Town & Country Planning Act 1990 (as amended)
Town & Country Planning (Development Management Procedure) (England) Order 2015
Application for Planning Permission for Works or Extension to a Dwelling

Development Single storey extension to rear of bungalow.

Location 3 Ely Gardens Aldwick

SITE PLAN
SCALE: 1:500

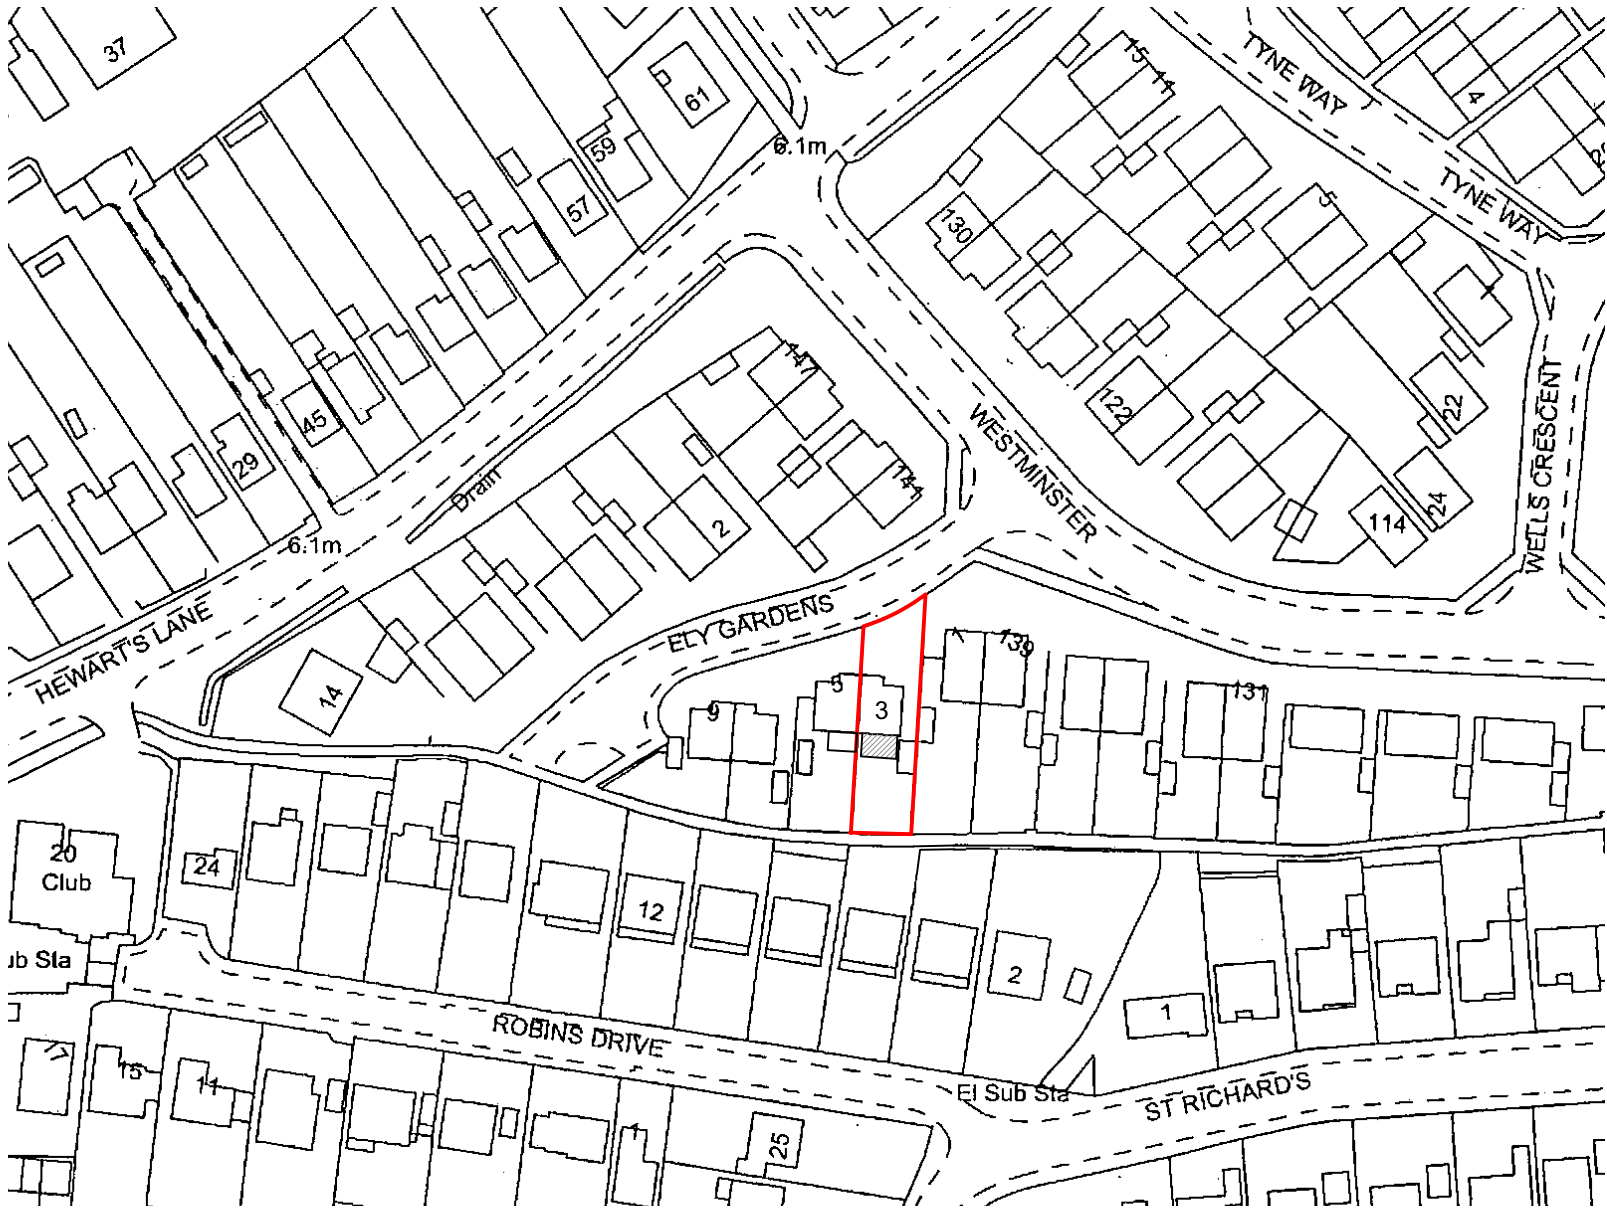
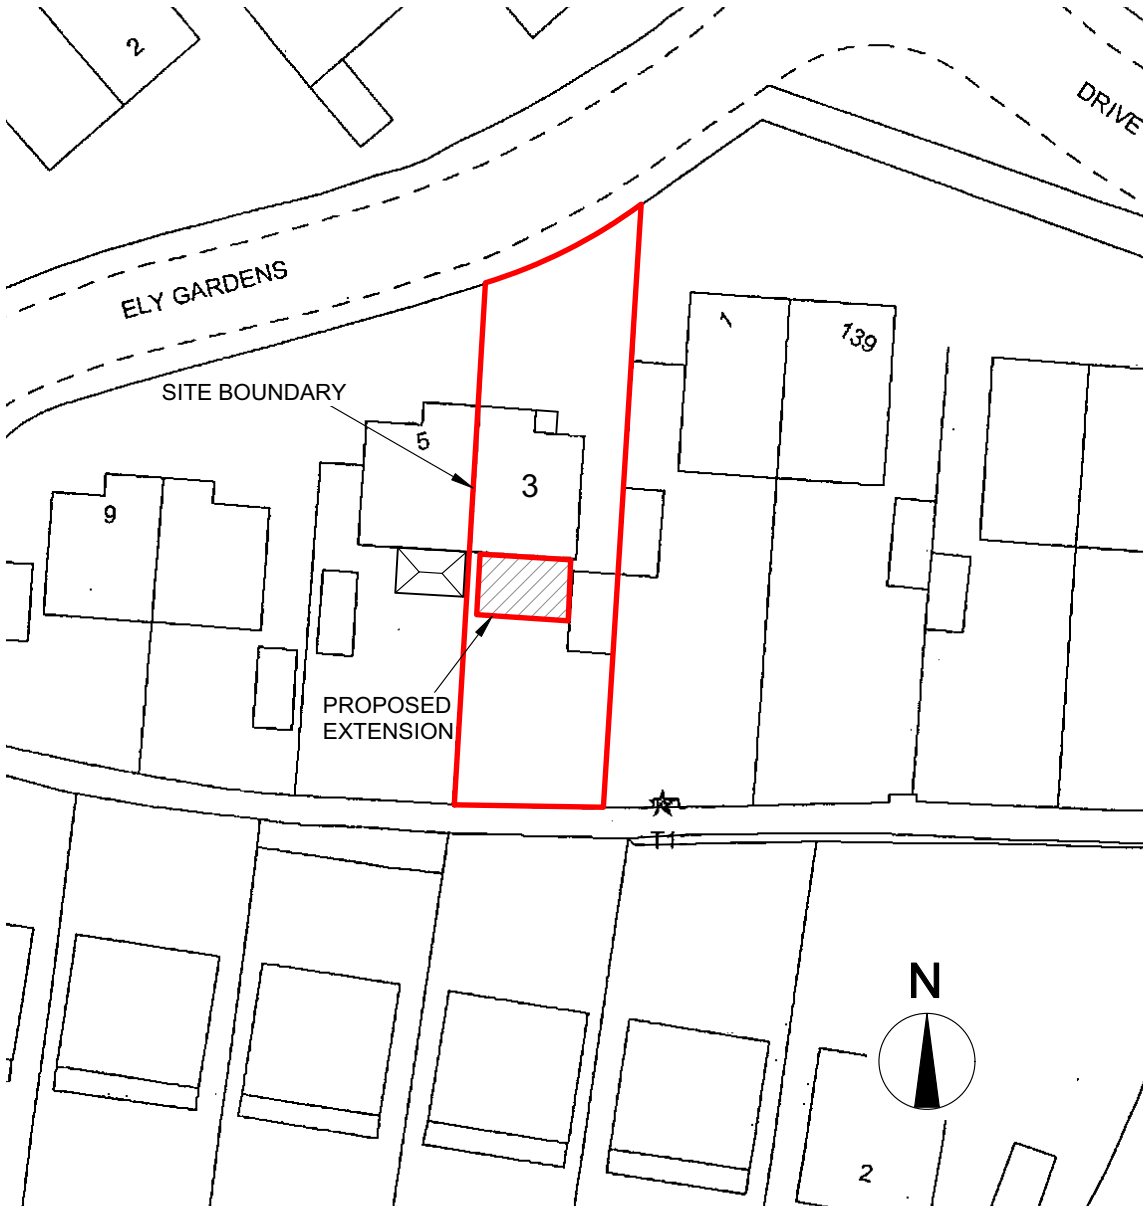
Block Plan: You are required to include dimensions on the block plan from the proposed extension to all site boundaries. Please amend.
